Application No: P/21/21/HH
Site Address: 6 The Green Pagham PO21 4RZ
Description of works: Loft conversion to form new first floor with front and rear dormer projection

Thank you for your internet representation made on 9th March 2021 which has been recorded as an objection with the comments as follows:

1 : 100

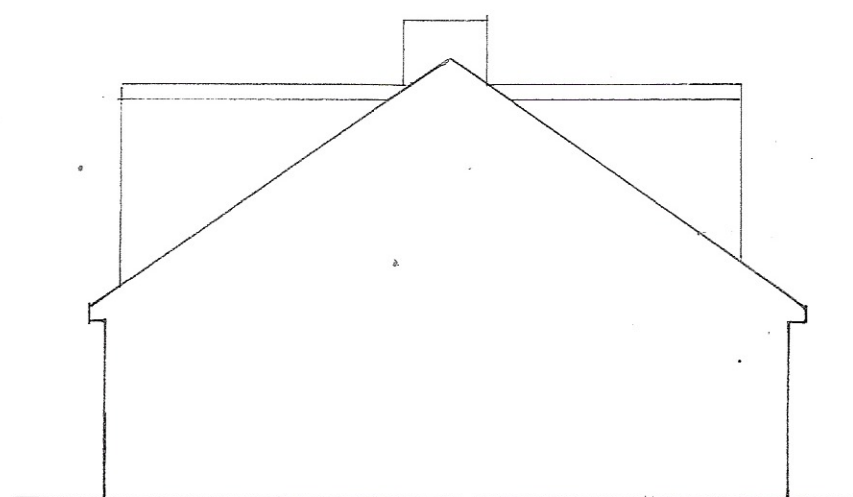
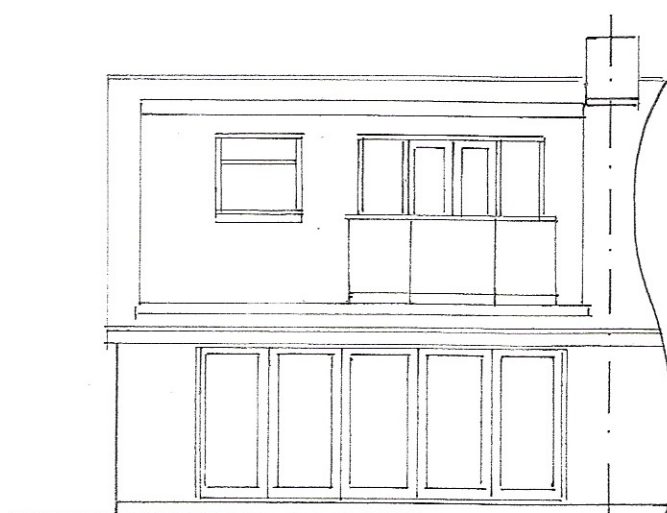
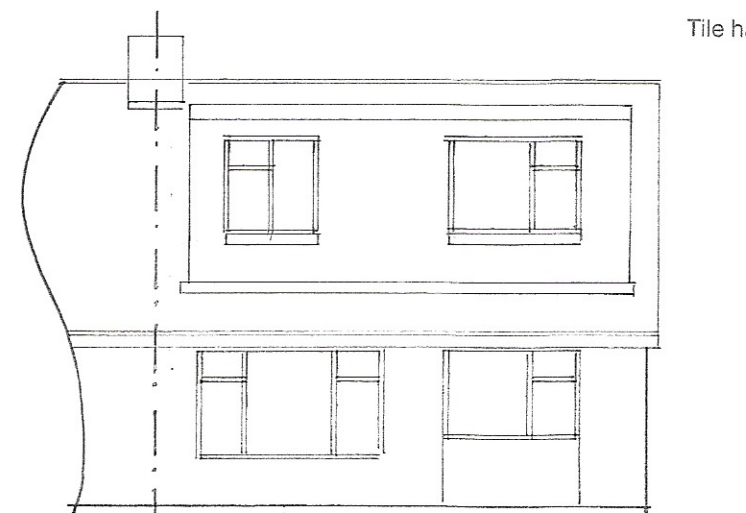
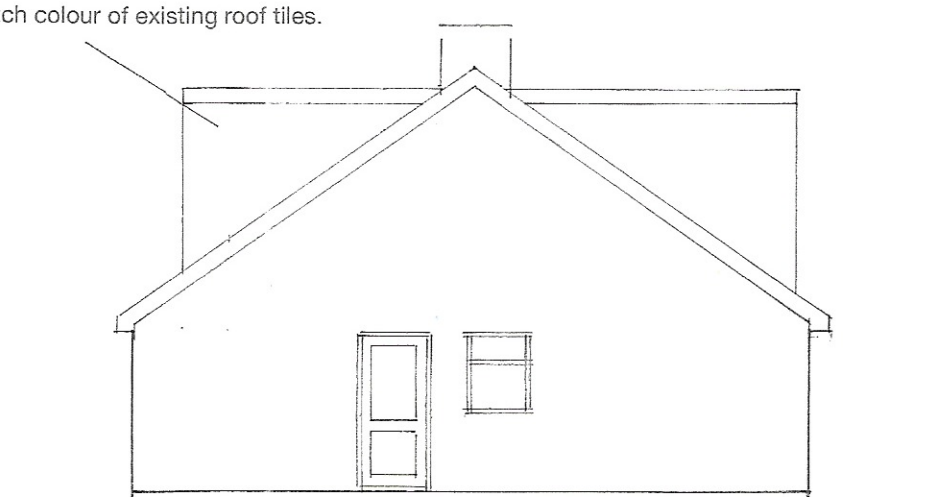
I feel that my privacy in front and rear gardens will be infringed.
The planing is not in keeping with the ambience of the area as there are no front dormer extensions on this road.
I am unable to verify from the plans what steel girders will be connected to my party wall.
